Meeting note

Project name	A303 Sparkford to Ilchester Dualling
File reference	TR010036
Status	Final
Author	The Planning Inspectorate
Date	31 May 2018
Meeting with	Highways England
Venue	Planning Inspectorate offices
Attendees	The Planning Inspectorate Susannah Guest – Infrastructure Planning Lead Richard Price – Case Manager Karen Wilkinson – EIA and Land Rights Advisor Michael Breslaw - EIA and Land Rights Advisor The Applicant Will Spencer – DCO and Statutory Process Manager (Highways England) Mark Wilson – DCO Advisor (Arup) Serena Gosden – Assistant Project Manager (MMSJV) Paula McGeady – Lawyer (Burgess Salmon) Julian Bosworth – Lawyer (Burgess Salmon)
Meeting objectives	Feedback on Draft Documents
Circulation	All attendees

TR010036: A303 Sparkford to Ilchester Dualling**Draft documents review**

A303 SPARKFORD TO ILCHESTER DUALLING
WORKS PLANS REGULATION 5(2)(J)
SHEET 2 OF 4

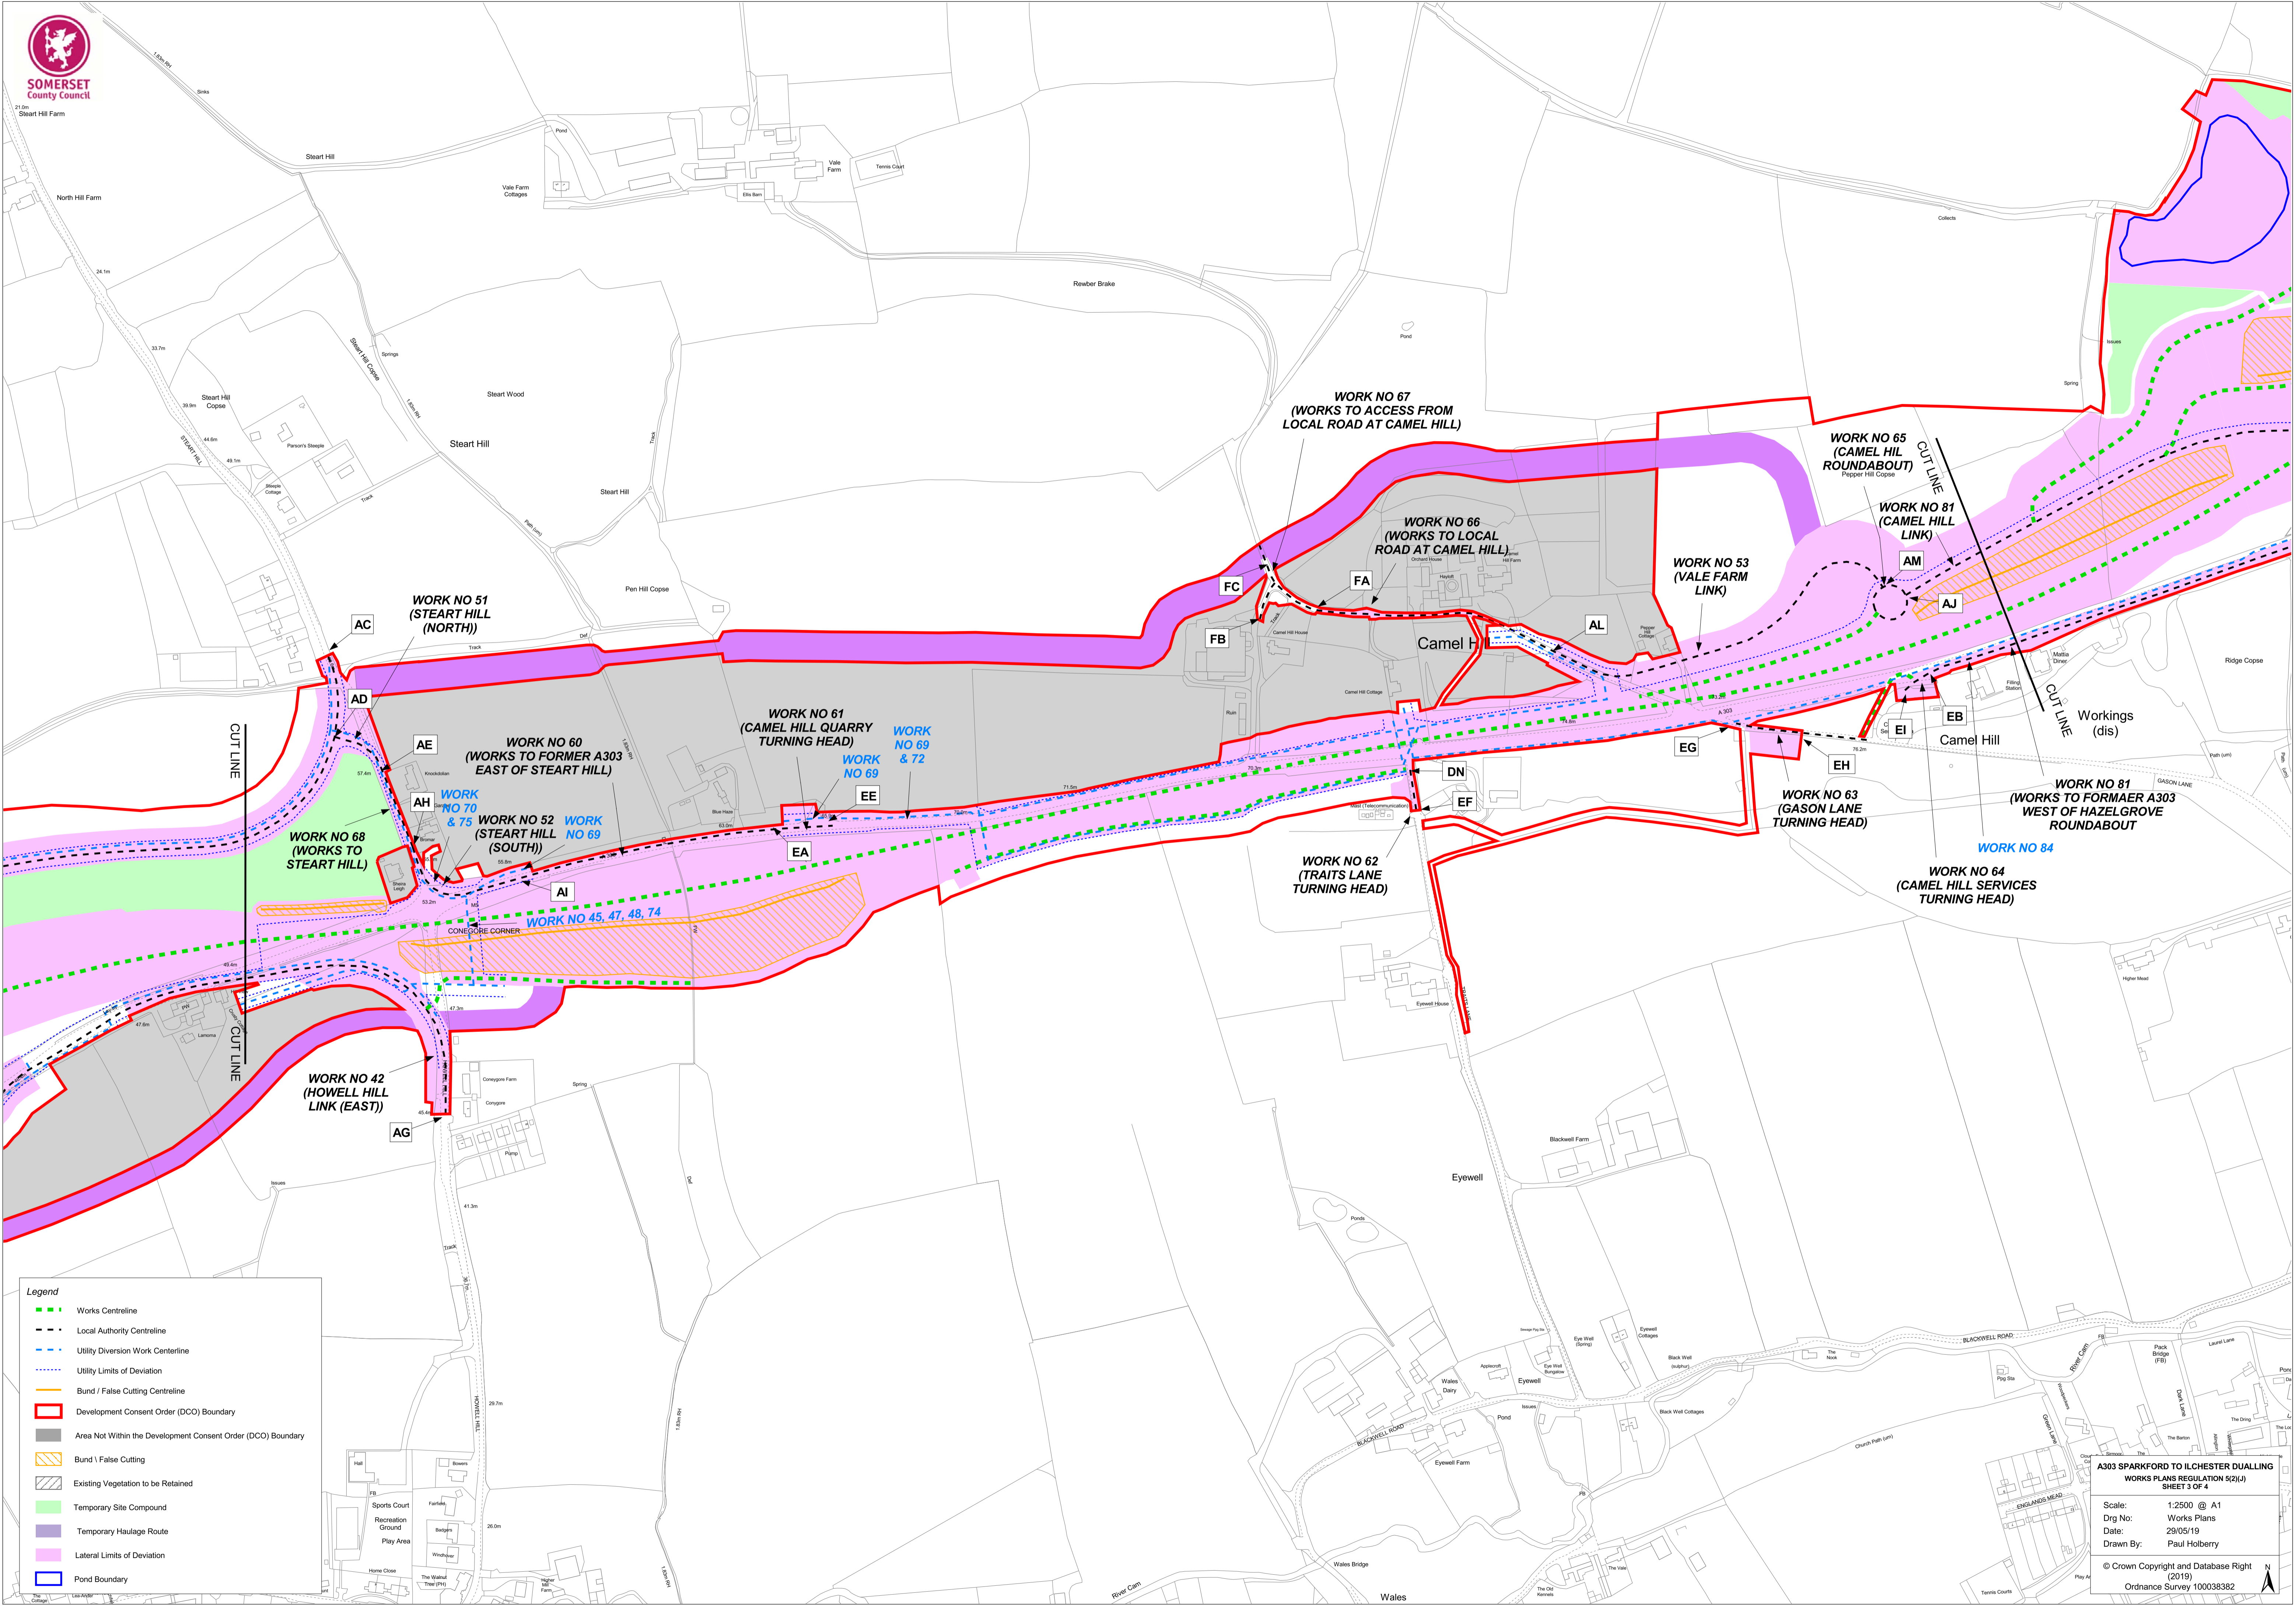
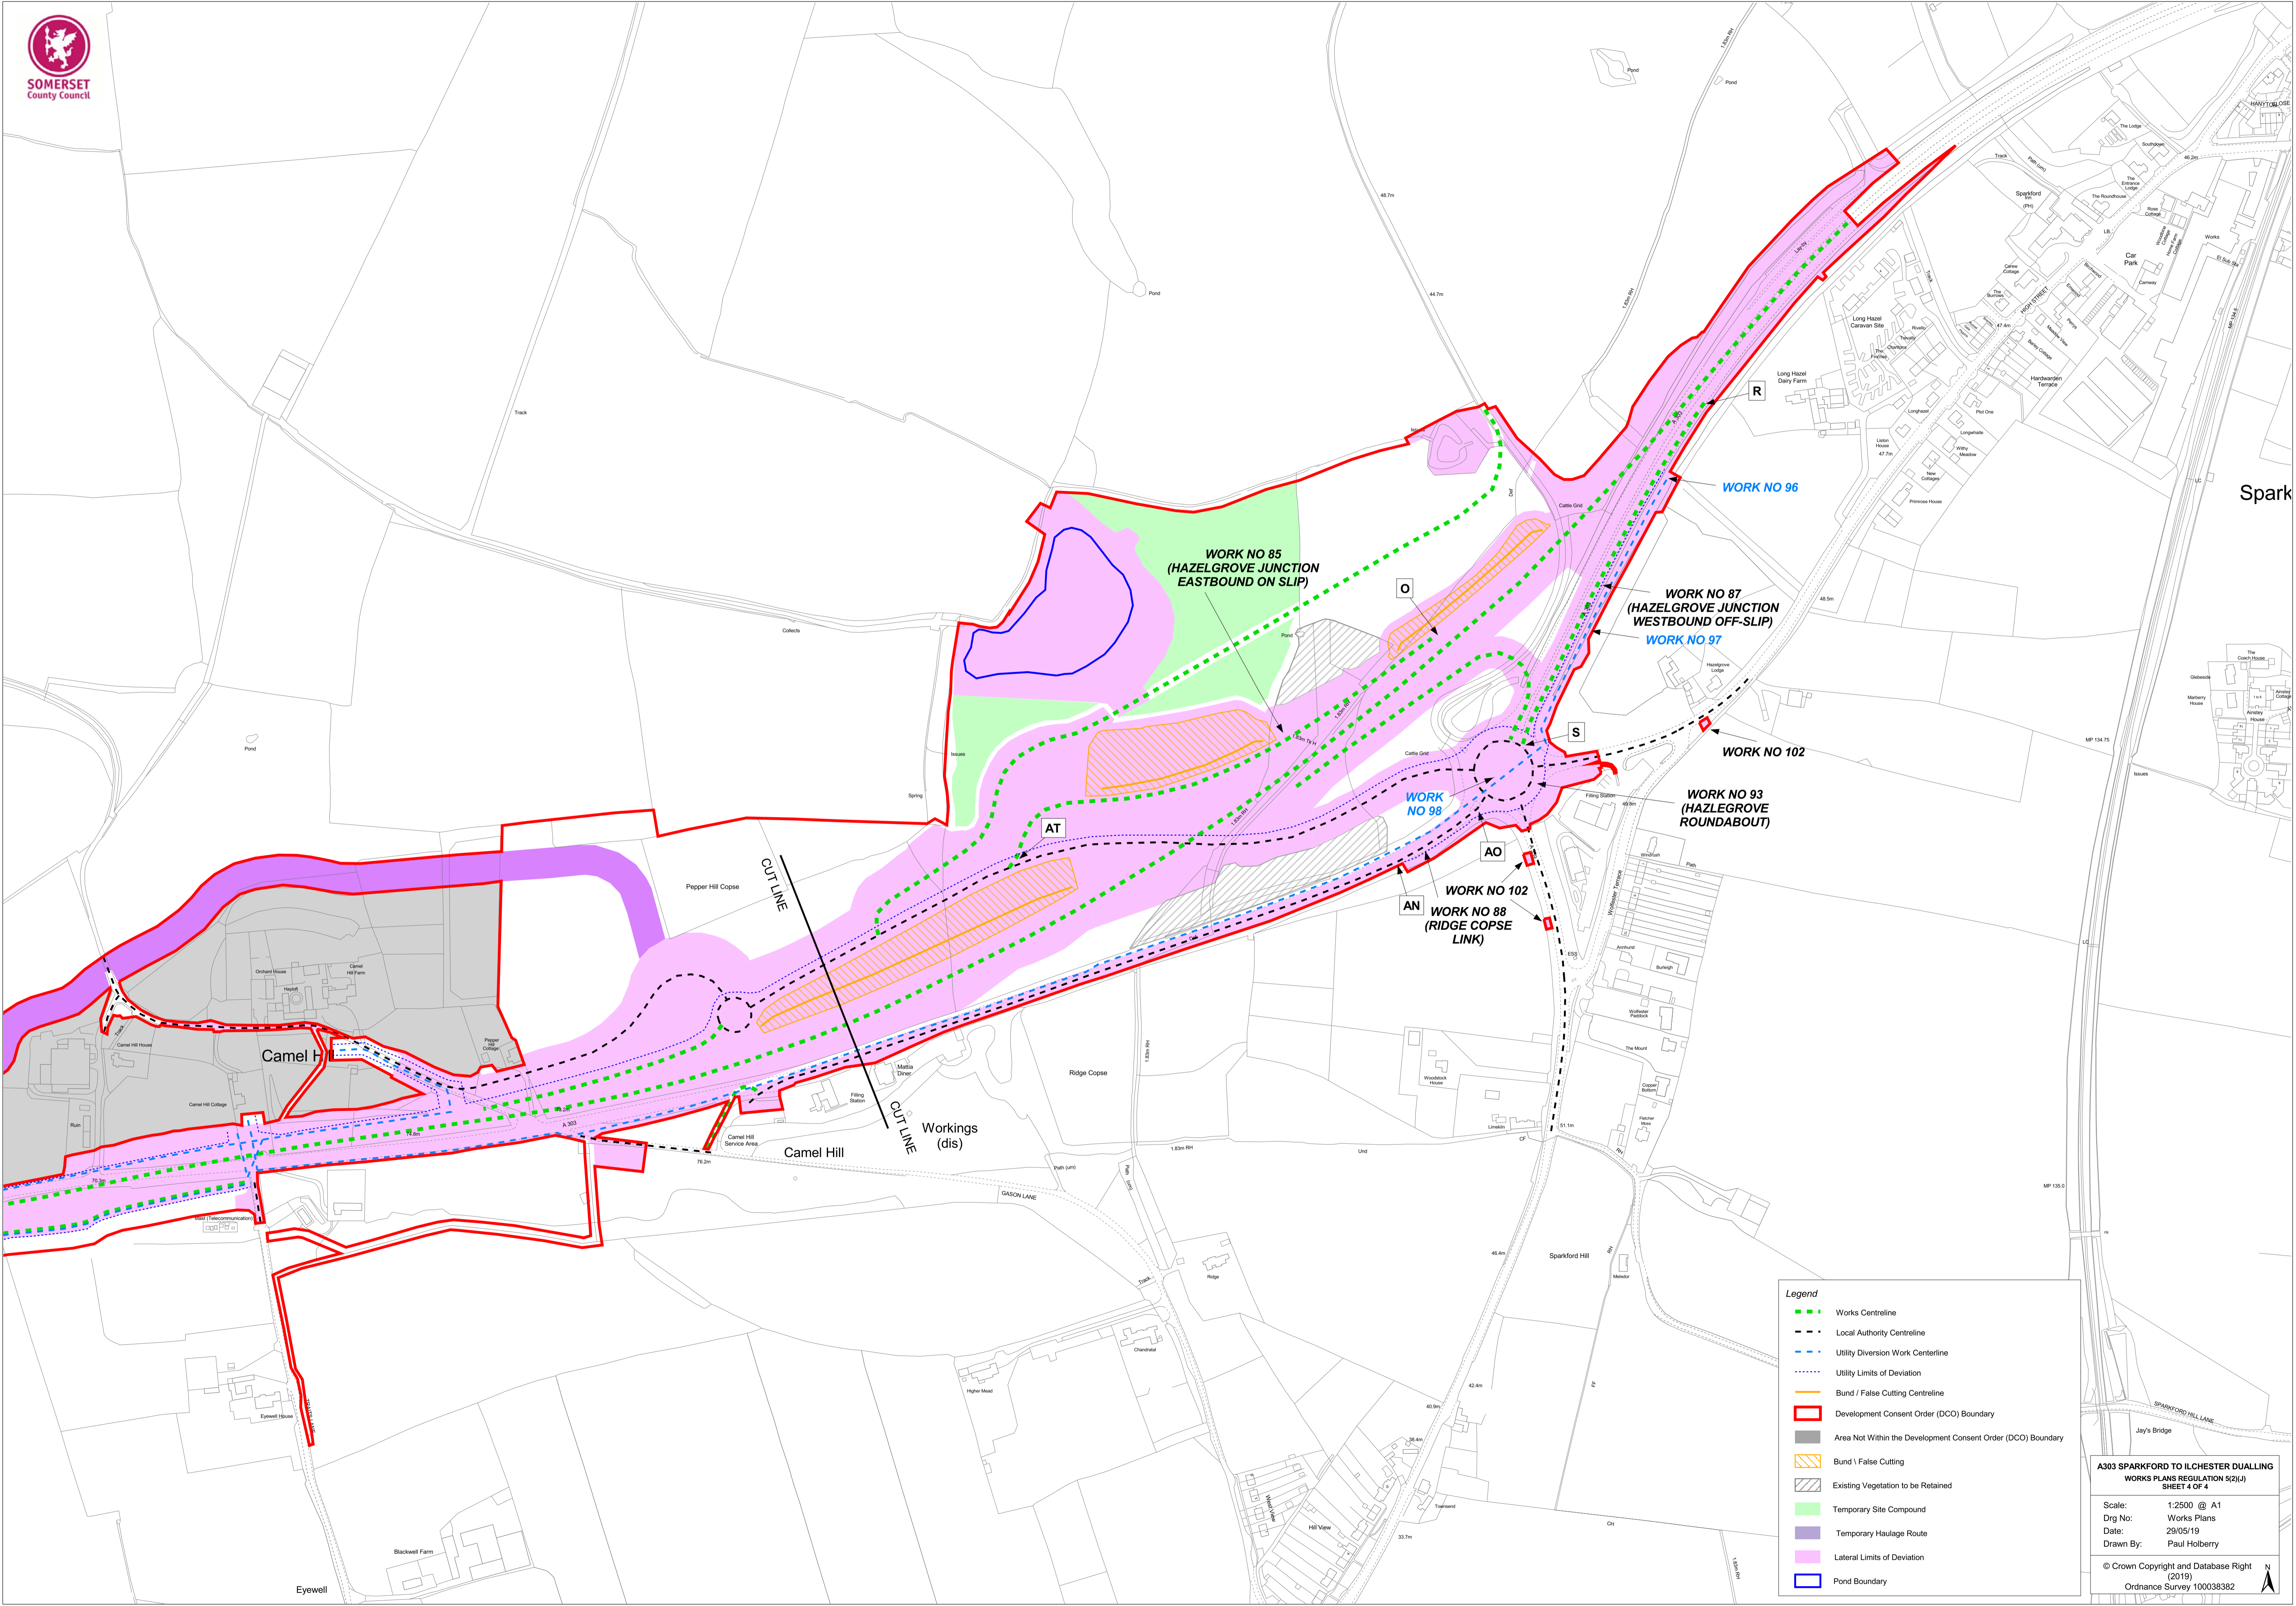
- The works centrelines appear very 'thick'. What meterage do they represent, and how is this reconciled with requisite certainty and the limits of deviation proposed?

- A number of arrows used to identify works either should be extended to meet the relevant works centrelines, or be extended to breach the boundaries of the relevant non-linear works eg Work 7, Work 19.

- In respect of 'ATTENUATION BUND' depictions: is the orange line a centreline?
- On sheet 1, there is an annotation for 'WORK NO.2' that points to an existing overbridge outside of the Order Limits.

- The graphic depiction of the 'DEVELOPMENT CONSENT ORDER BOUNDARY' in the legend is absent.
- In respect of Work 11 and other "*works associated with the retention of existing A30*" eg Work 21, Work 39: what works are they? If they are linear, should there be a centreline between the reference points cited? If not, what are the works boundaries?

- In respect of eg Work 22 and Work 26: 'noise bund' and 'false cutting' are both depicted as 'ATTENUATION BUND' on the Works Plans. Does this provide sufficient clarity?

- In respect of Work 24: in Schedule 1 to the draft DCO it is described as being constructed between reference points 45 and 46. Reference point 45 does not appear to extend to the end of the work as proposed. What is the spur to the east, and should it be described in Schedule 1 to the draft DCO?

- The works numbers are non-sequential eg Work 27 and Work 32 are missing. Will this be explained in the application?
- In respect of Work 38: should Pond 6, whilst an existing attenuation pond, be identified by the same blue line depicting 'ATTENUATION POND BOUNDARY' in the legend.

- In respect Work 44: should reference points be provided in Schedule 1 to the draft DCO?
- Work **45** in Schedule 1 to the draft DCO appears to describe Work **55** on the Works Plans. Should reference points be provided as per comment on Work 44.

- In respect of Work 50: should the second reference point in the description in Schedule 1 to the draft DCO be '83'?
- Work 52 is described in Schedule 1 to the draft DCO as shown on sheets 1 and 2 of the Works Plans. It is not annotated on Sheet 1.

Regarding the Inspectorate's comments on the draft Works Plans (**Annex A**), the Applicant stated that they would be amended to provide greater clarity prior to submission. In respect of the Land Plans, the Inspectorate advised for the Applicant to refer to the Land Plans for the M20 Junction 10a as an example of where a contrasting colour had helpfully been used to depict plot boundaries. The applicant noted the advice but would consider this further on the basis that red plot boundaries are generally standard practice.
